**Hay Shire Council Submission**

**Romani Battery Energy Storage System (BESS) – Environmental Impact Statement**

**SSD Application:** SDD-67105475

**Proponent:** Romani Energy Pty Ltd

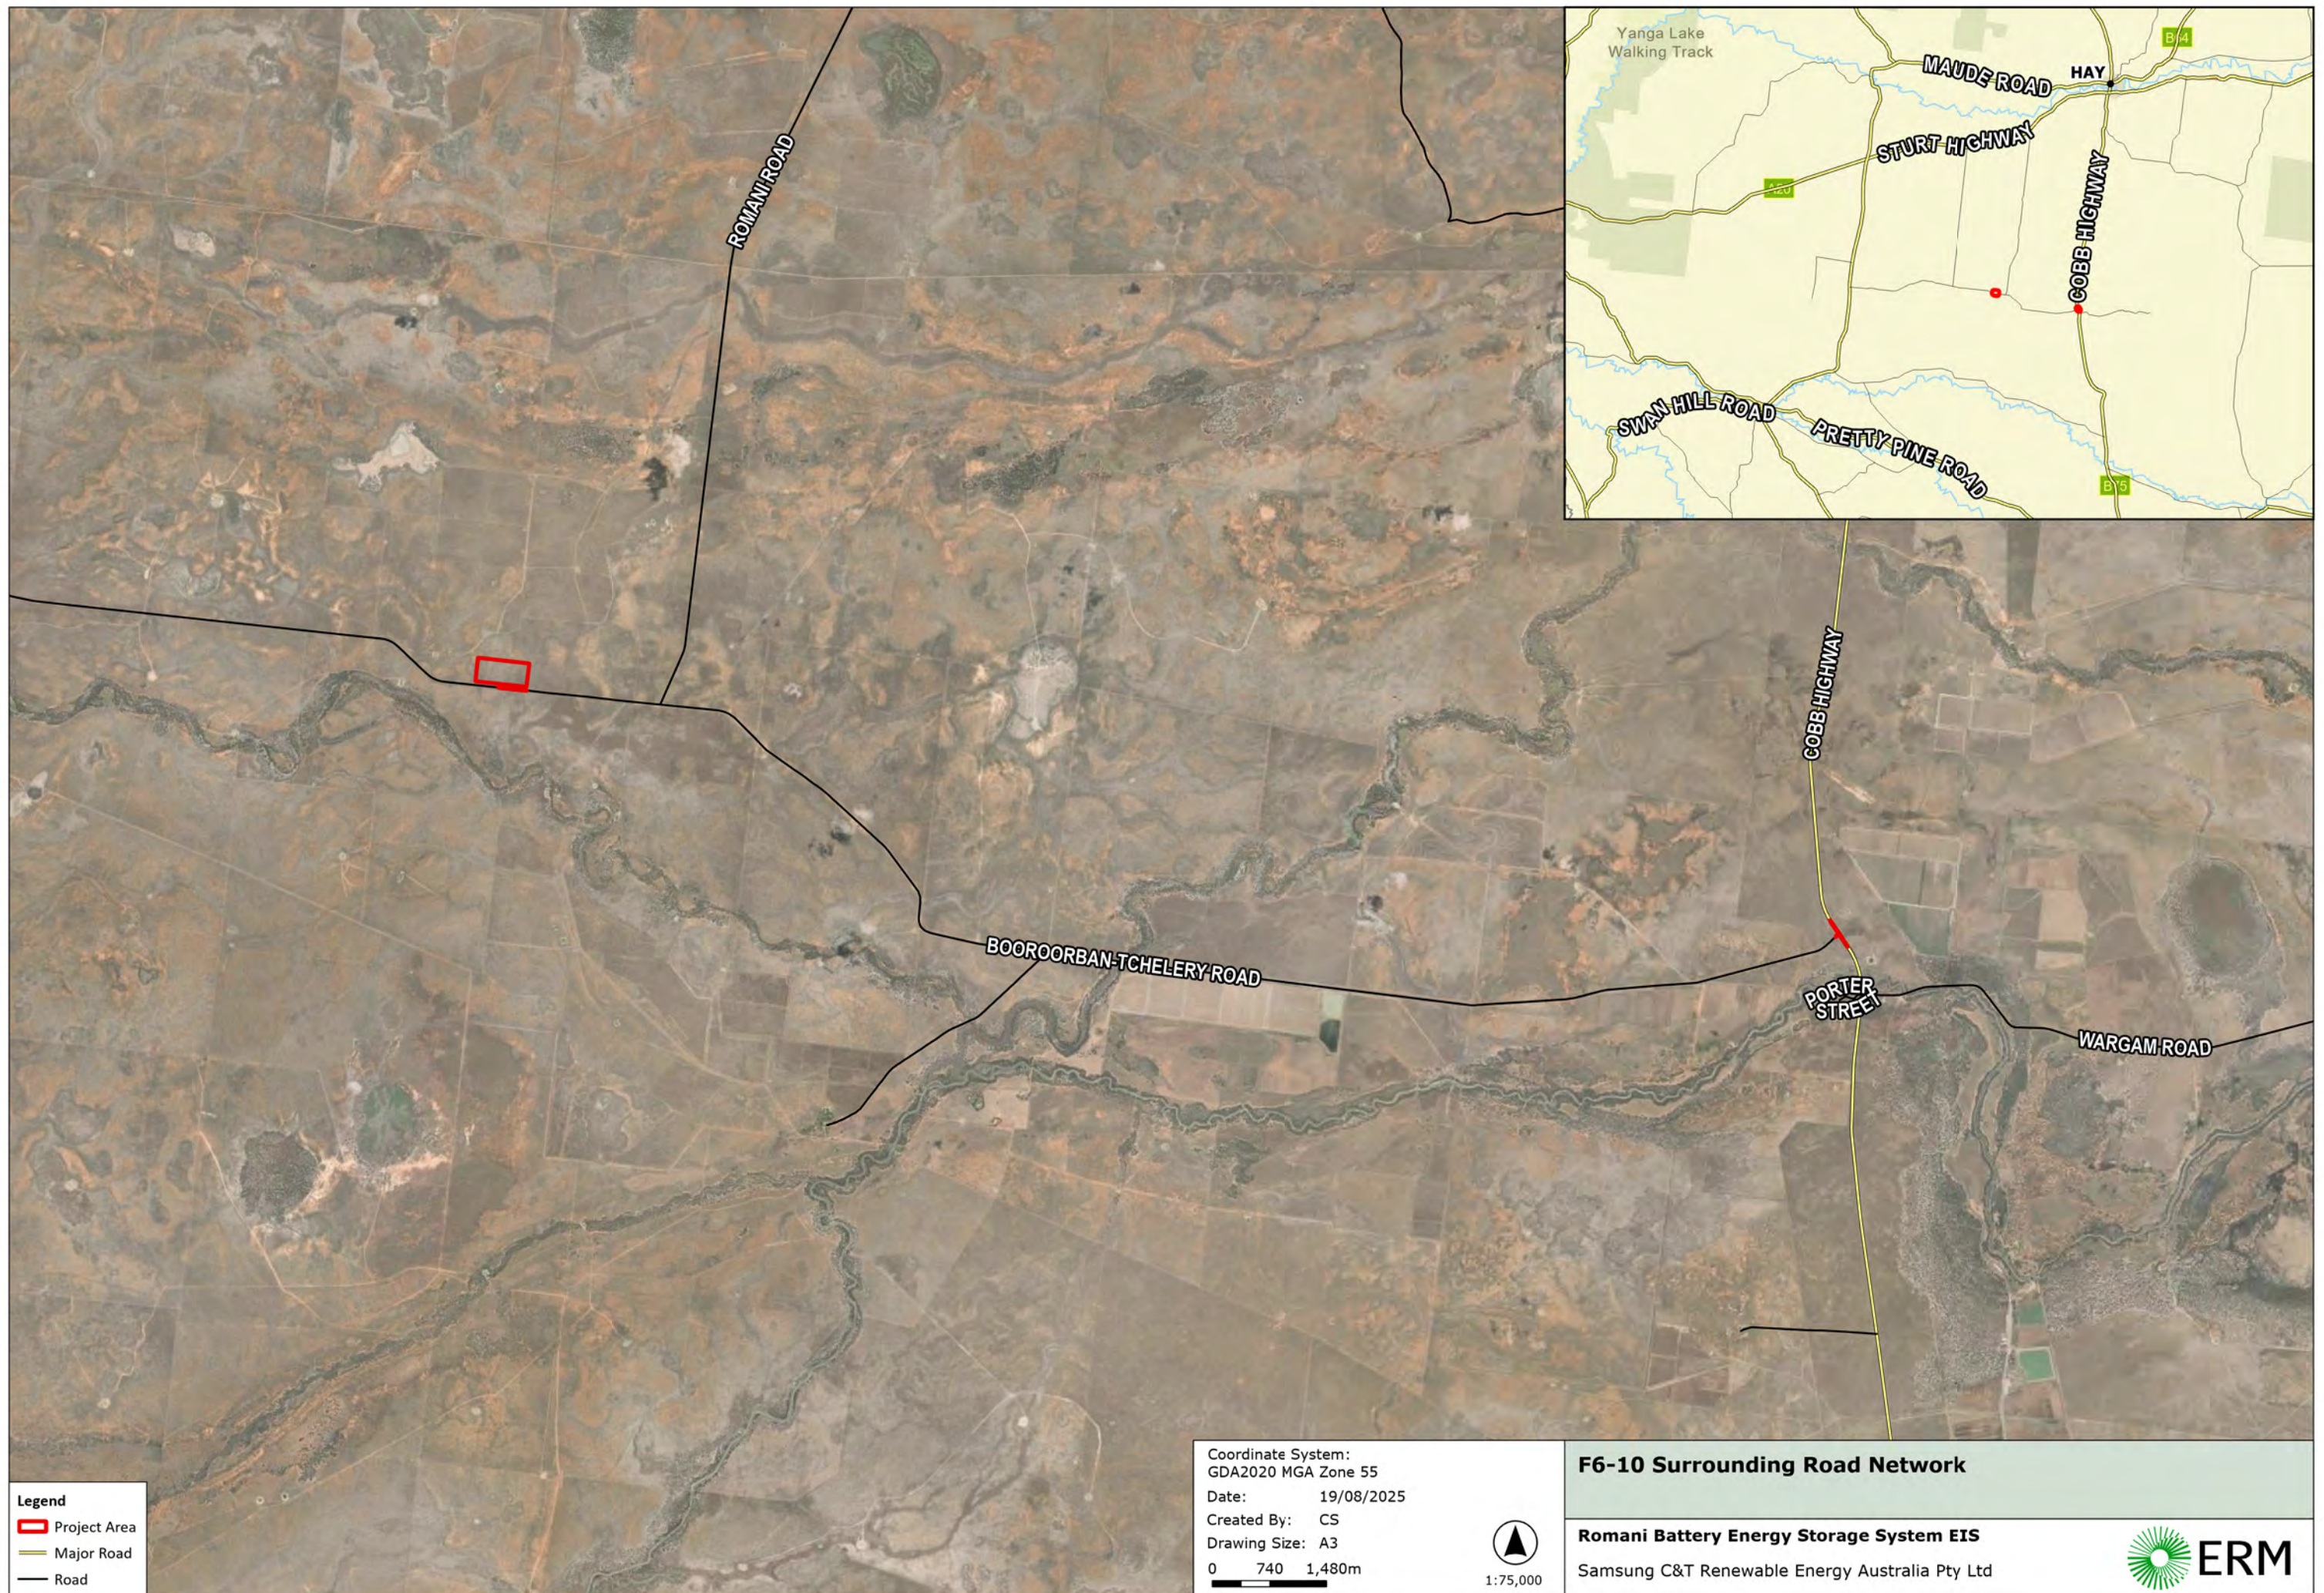
- It would appear that the TIA has not been delivered in consultation with Local Road Authorities
- TIA does not identify any other local roads other than Boorooban – Tchelery as servicing the project. Council believes Romani, Glenhope and Maude Roads are most likely to be used by contractors, particularly given the planned usage of Boorooban – Tchelery Road by other energy projects. Council requests that these roads are considered in the TIA. The TIA should identify the likely impacts for raw materials deliveries and construction workforce movements.

- Local roads within Hay Shire are designed primarily for low traffic volumes and agricultural plant, not sustained heavy construction traffic. There will be a requirement for upgrades on local roads. All upgrades are required to be Austroads Design Guide and council engineer satisfaction. Council requests detailed Transport Management Strategy to be developed in consultation/agreement with all Local Road Authorities, in conjunction with the proposed Transport Management Plan.
